Application Ref:	3/2021/0539	 Ribble Valley Borough Council www.ribblevalley.gov.uk
Date Inspected:	07/06/2021	
Officer:	RB	
DELEGATED ITEM FILE REPORT:		APPROVAL

Development Description:	Conversion of garage to additional living accommodation with mezzanine level, single storey extension and Demolition of existing outbuilding to be replaced with new detached double garage. Resubmission of 3/2020/0770.
Site Address/Location:	Ravenswing Farm, Further Lane, Mellor BB2 7QB

Proposed detached garage plan and elevations 1:50 @ A2

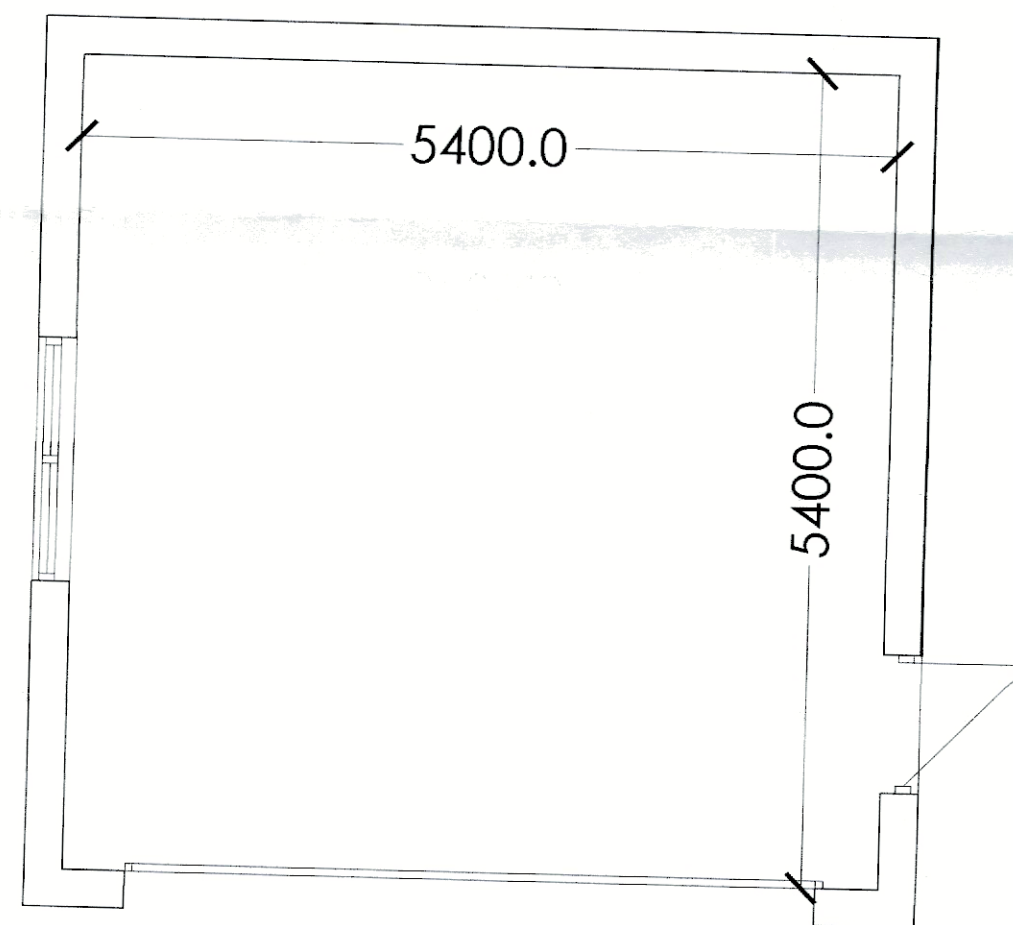
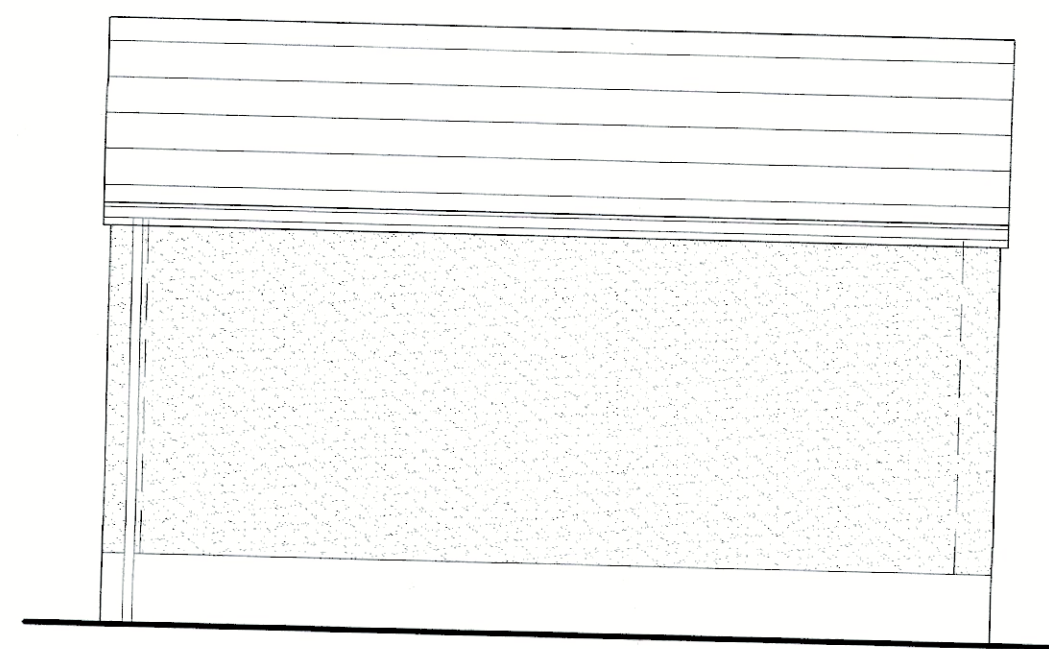
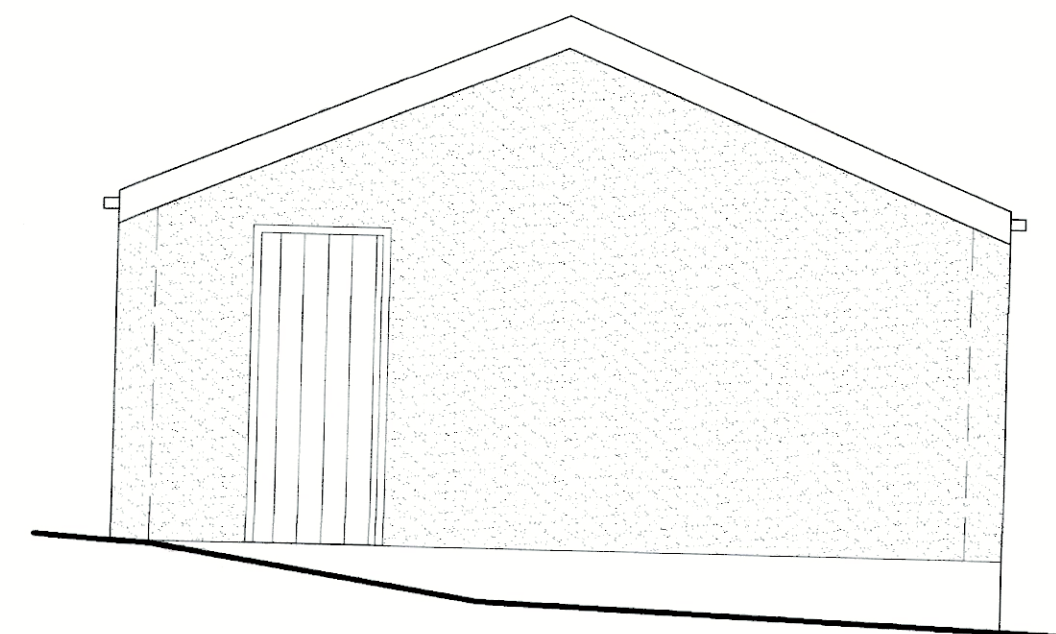
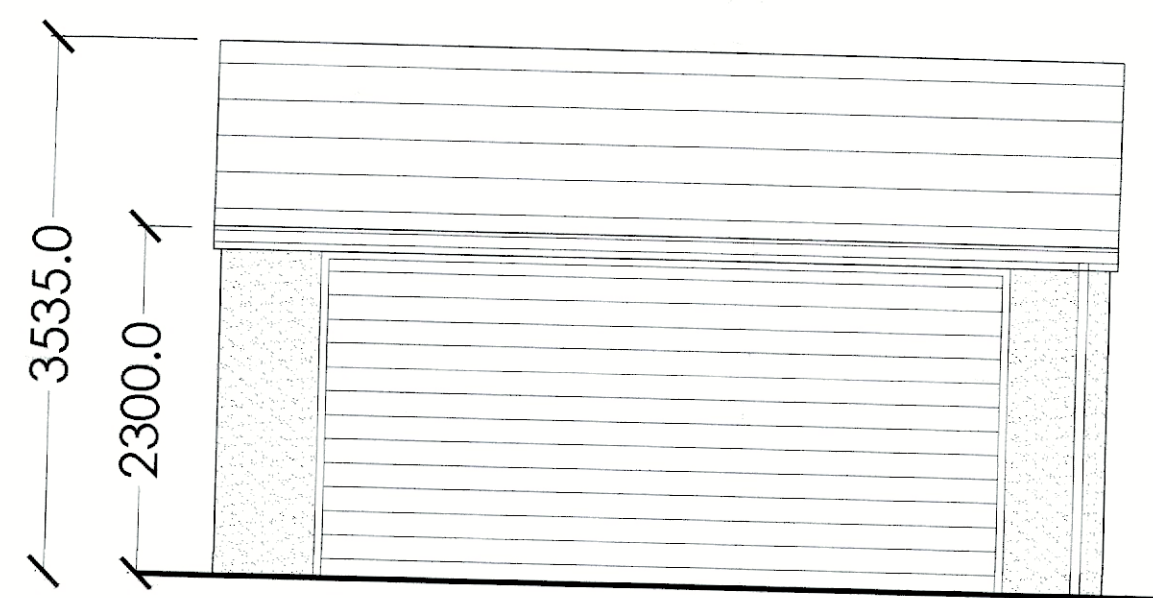
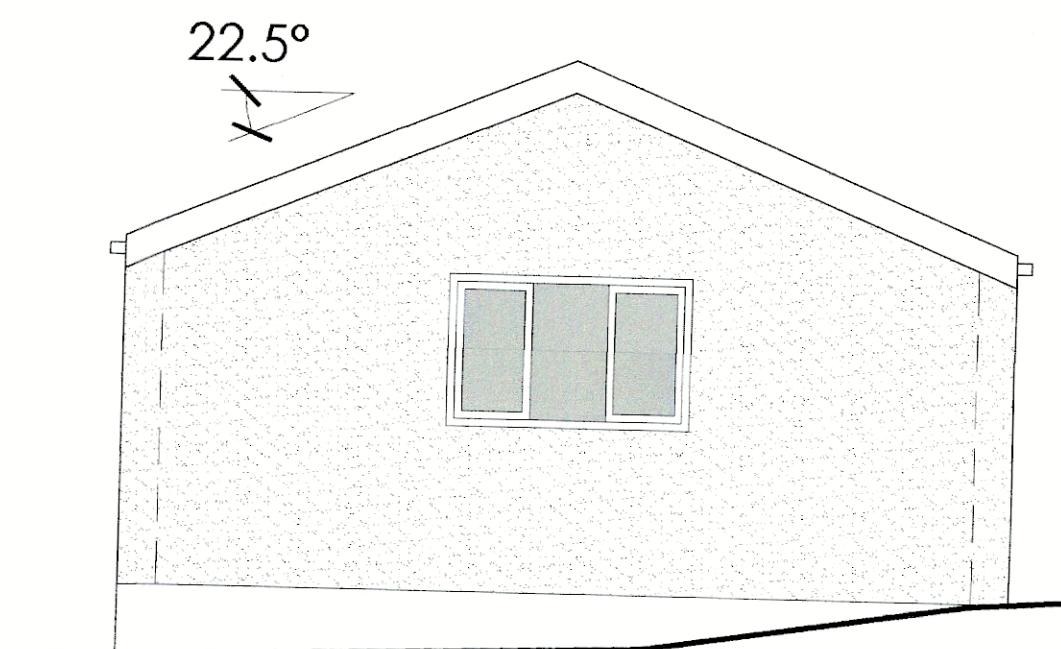
Demolition of existing domestic store to be replaced with a detached double garage of a larger footprint. The footprint of the garage will be 6m by 5.9m with a pitched roof measuring 2.3m at the eaves and 5.35m at the ridge. The garage will be faced with render with a concrete tile roof and aluminium windows and garage doors.

The proposed garage will be sited on a similar footprint to the existing outbuilding having a slightly larger footprint and increased ridge height of 0.5m. The garage building is sited over 10m from the front elevation of the neighbouring property Pipers Pool and no windows are proposed on the rear elevation that will face this neighbour. As such it is considered that the garage would have limited impact on this neighbour.

Subsection D states that 'the replacement of a building, providing the new building is in the same use and not materially larger than the one it replaces'. The development proposes the demolition of the existing domestic outbuilding at the site and for it is to be replaced with a new detached garage in a new location. It is therefore considered that the new building would have the same use as a domestic building associated with the main dwelling. The new detached garage would have a minimal footprint increase of 4m² and a minimal height increase of 0.5m. As such it is not considered to be materially larger than the one it replaces.

The proposed replacement garage will have a minimal footprint increase and increased ridge height. The detached garage will be faced with render to match the main dwelling and has been designed to reflect a typical detached garage. As such the replacement building is considered to have minimal impact on the visual amenity of the area.
